Planning Application BR/76/19/PL
33 Shelley Road, Bognor Regis

No.	Revision/Issue	Date
Proposed Conversion Proposed Elevations Planning		
Date March 2019		
Scale 1:50

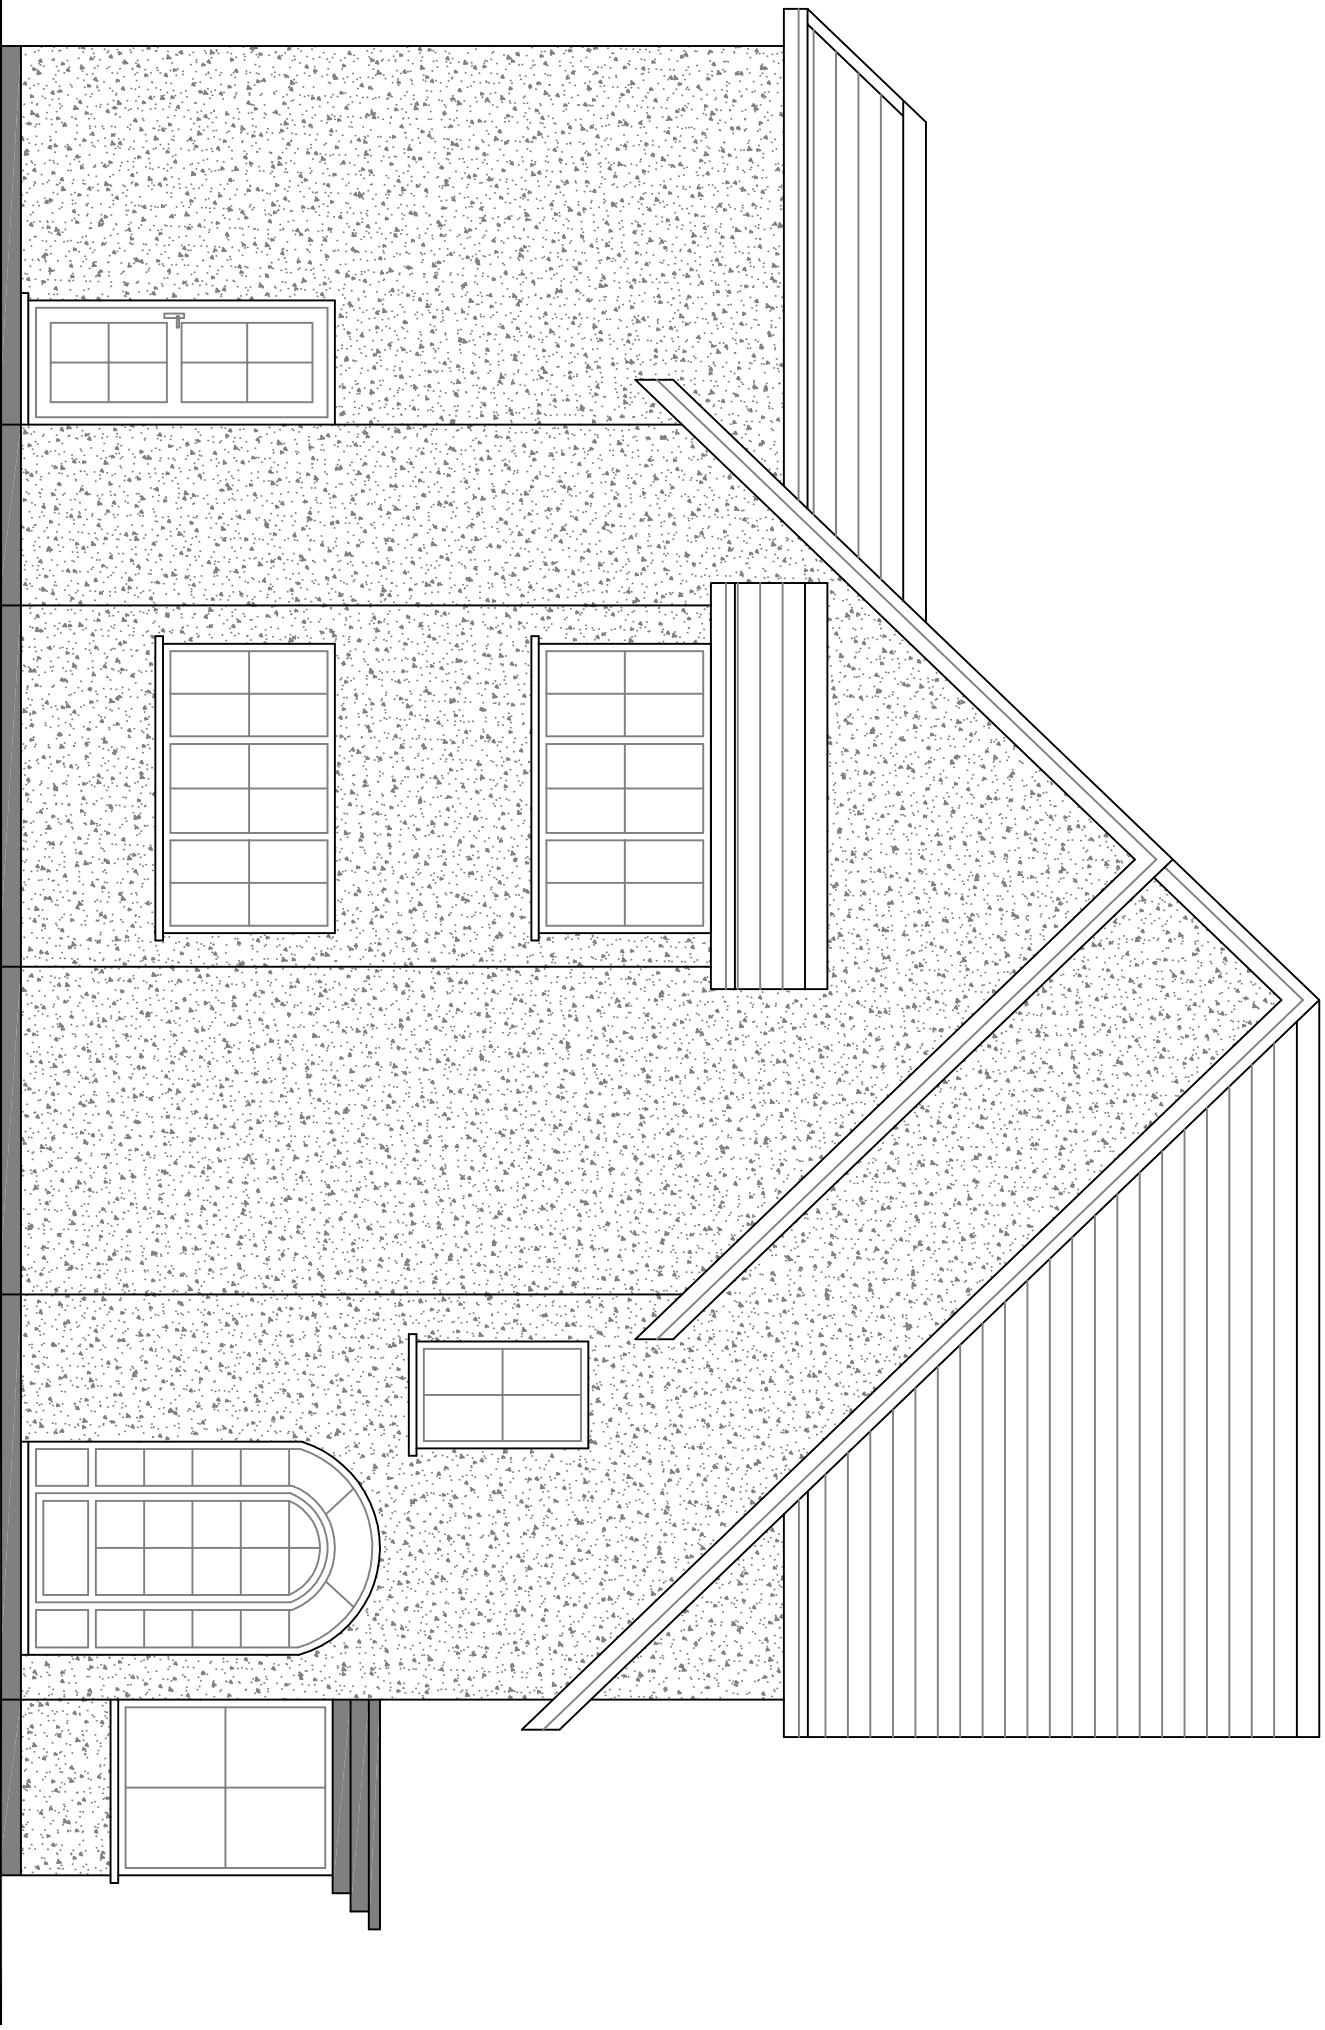
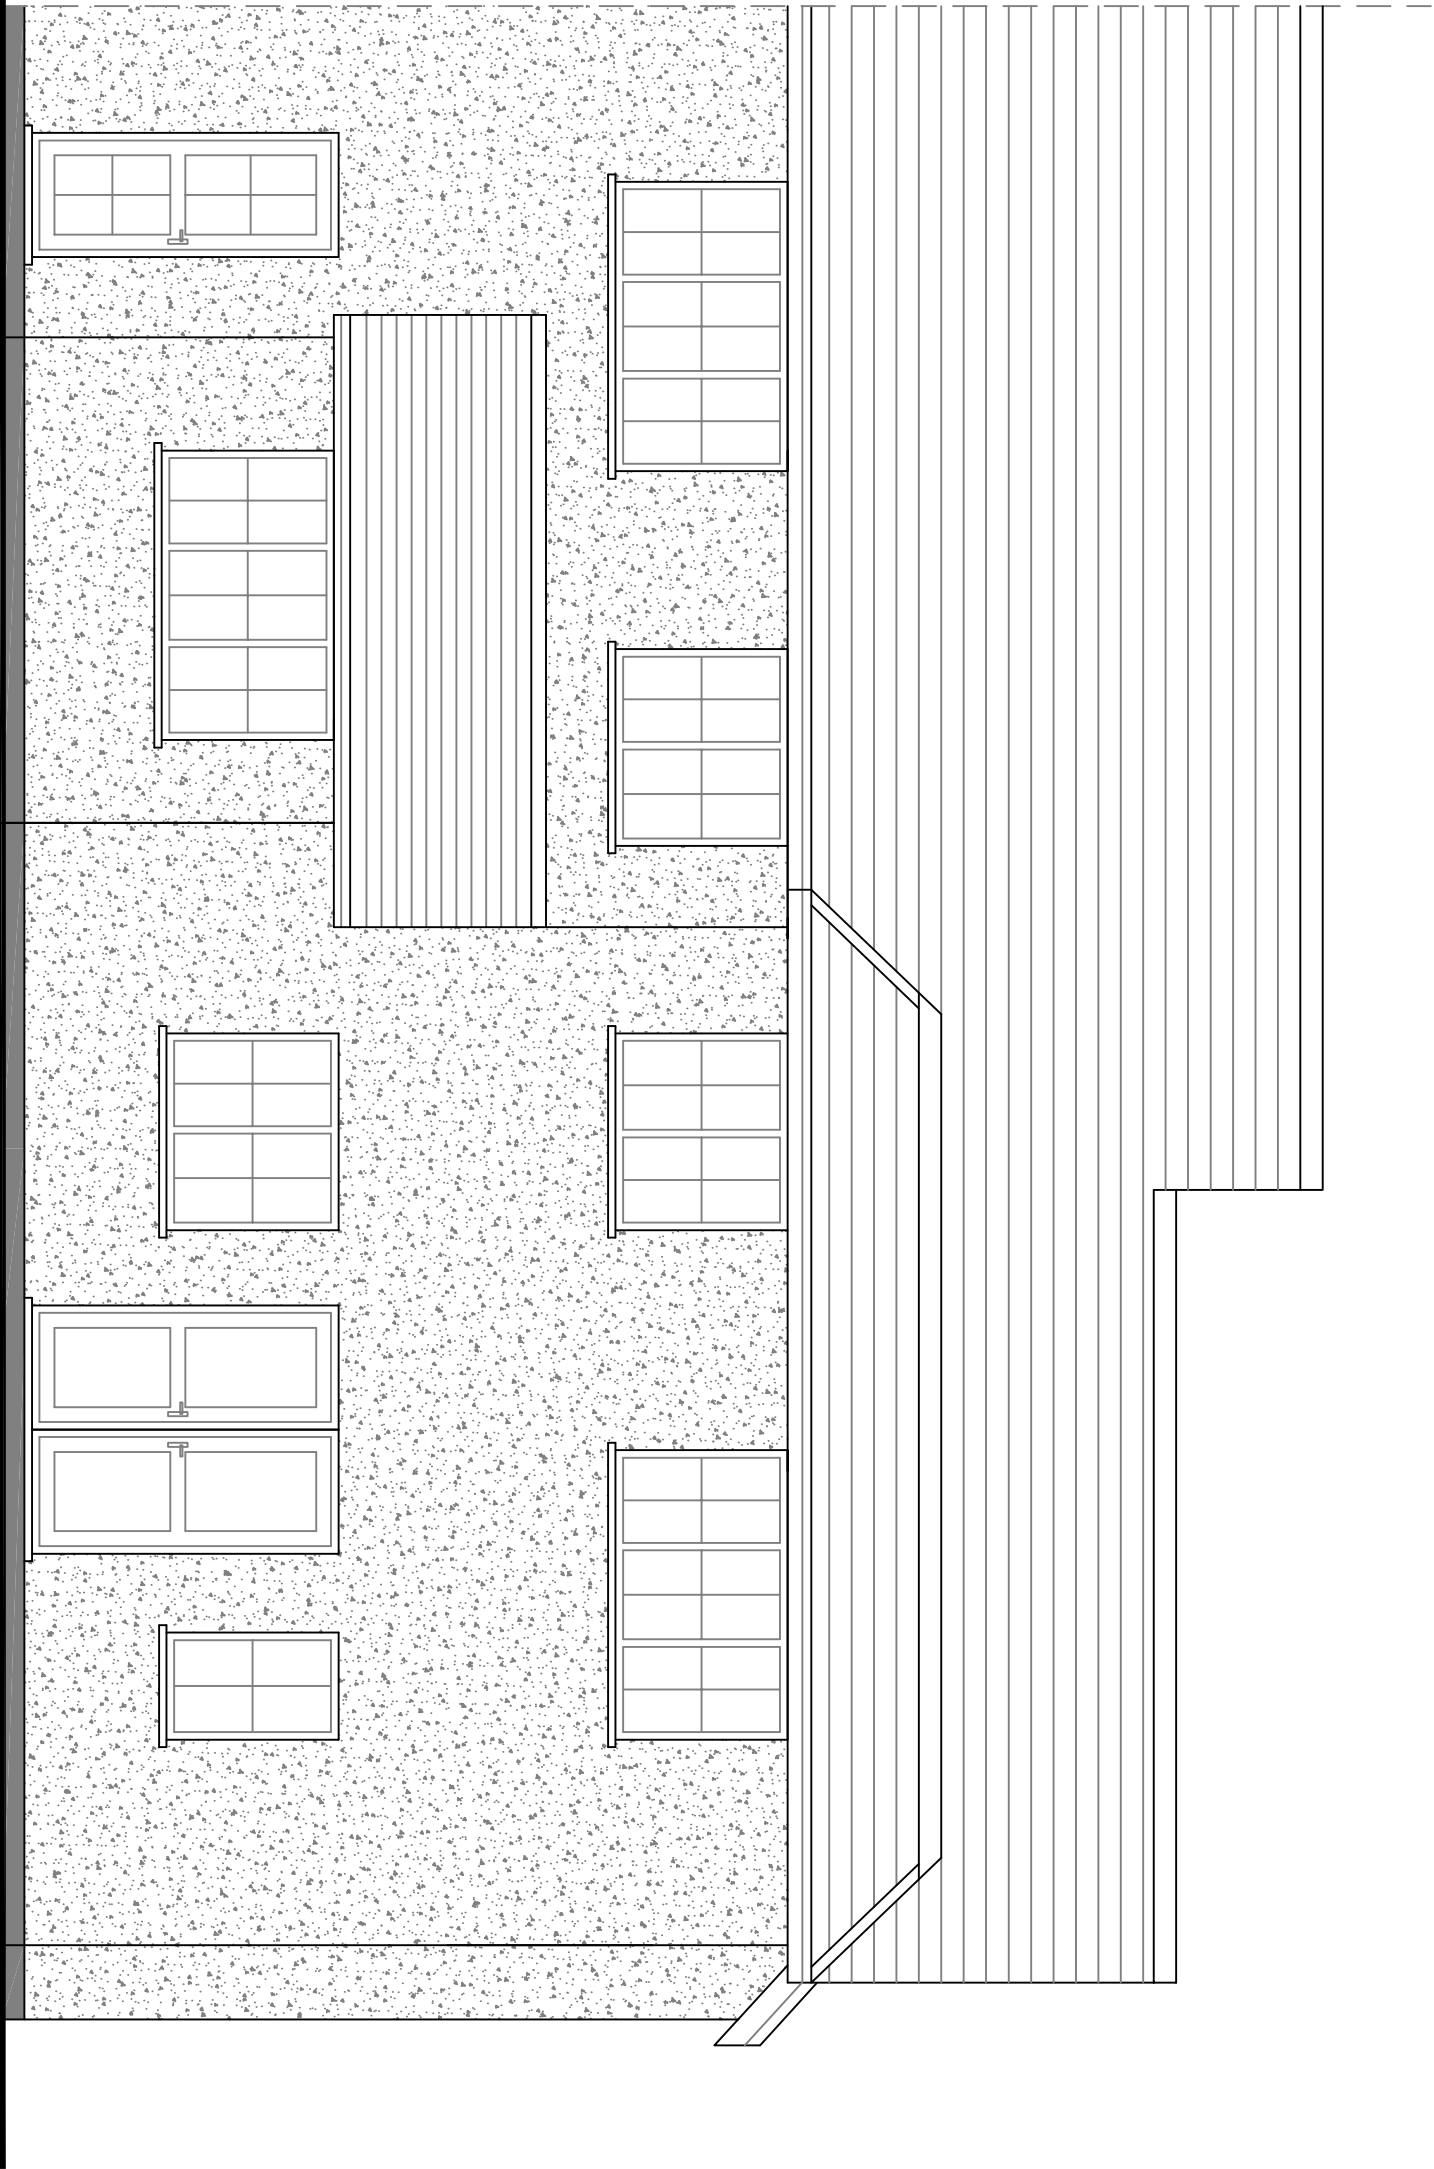
- ① This is an overdevelopment of this site. The property has already been divided once to create the new house i.e. 35 Shelley Road.
- ② The current wooden conservatory at the rear of the property is single storey and glazed on all sides. This allows light to pass onto the kitchen area of the adjacent house i.e. 31 Shelley Road. The proposed two storey extension to replace this would block all light from reaching this part of 31 Shelley Road. Surely this is not permitted under planning law and practice and the occupants of 31 Shelley Road have a right to light.
- ③ Although provision has been made for off-street parking at both the proposed new properties there is still the potential for increased on-road parking near the junction with Elm Grove. This ~~can~~ be a

(IV) The proposed new properties are totally out
of character with all the other properties in
Shelley Road and adjacent roads. These being
detached or semi-detached in their own plots.
